From: Public Access DC Comments
Sent: 29 April 2018 22:28
To: Public Access DC Comments
Subject: Comments for Planning Application 18/00220/F

Address: Land North Of Milton Road Adderbury Oxfordshire
Proposal: Change of use of agricultural land to sport/recreation and community use
Case Officer: Caroline Ford
[Click for further information](#)

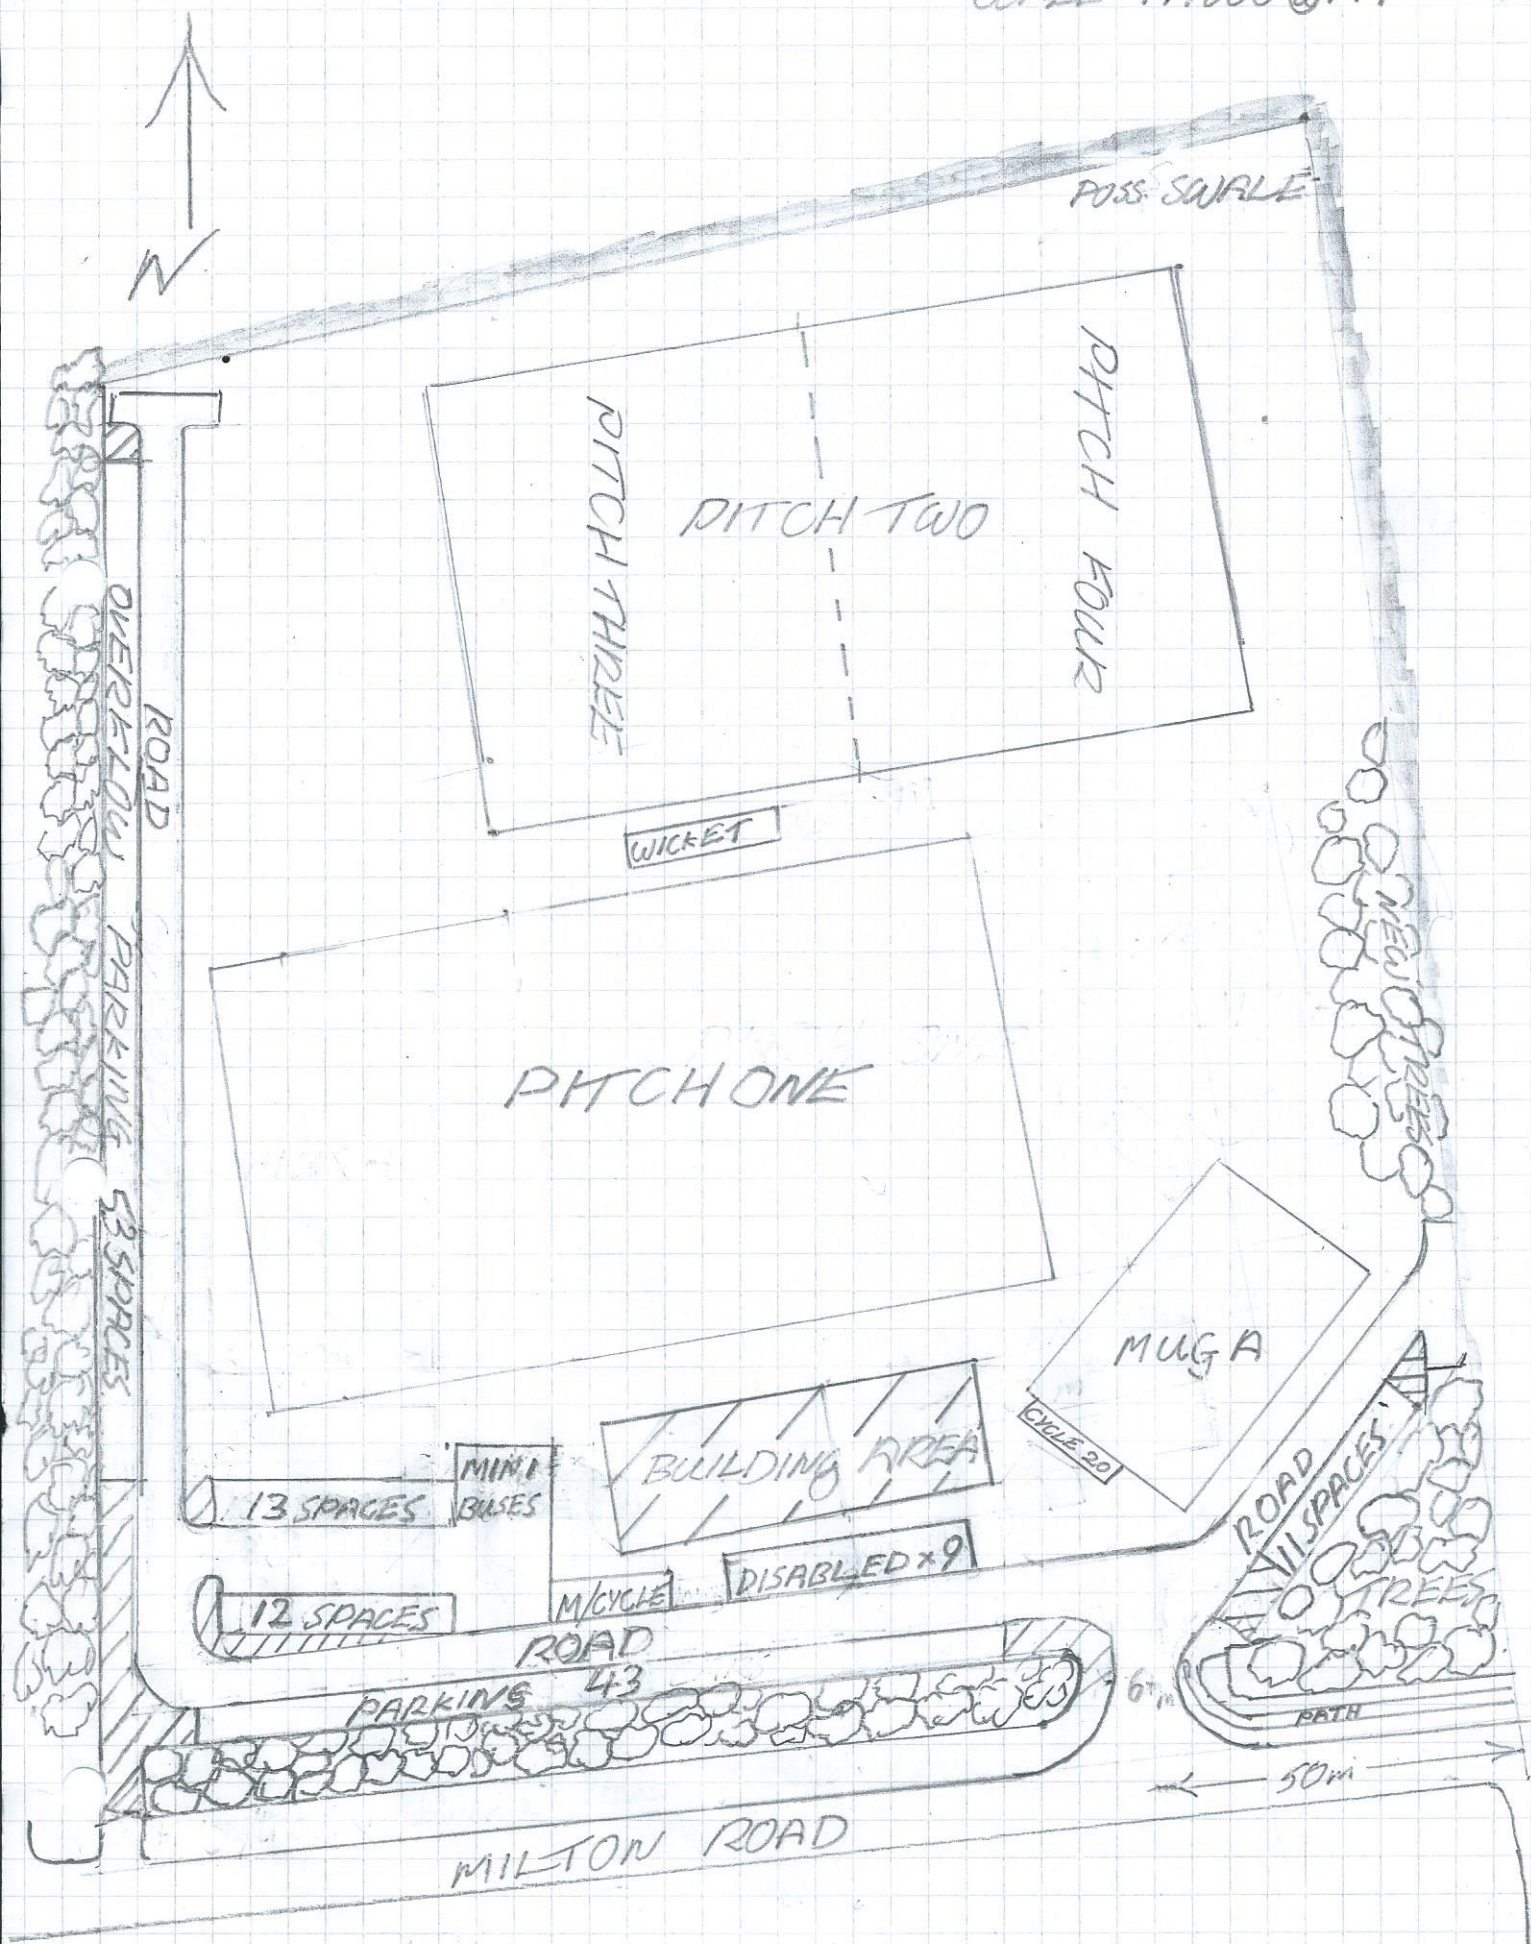
The drawing that the Parish Council has submitted with the proposal, while indicative, is unrealistic and not to scale. To ensure users of the new facilities do not park on neighbouring roads, there should be provision for at least 68 cars (four football teams of 11 players and 3 substitutes (56), two team managers and their staff (6), referee and linesmen for each pitch (6)). It is unclear whether there would be enough space for this because the plan submitted is not accurate.
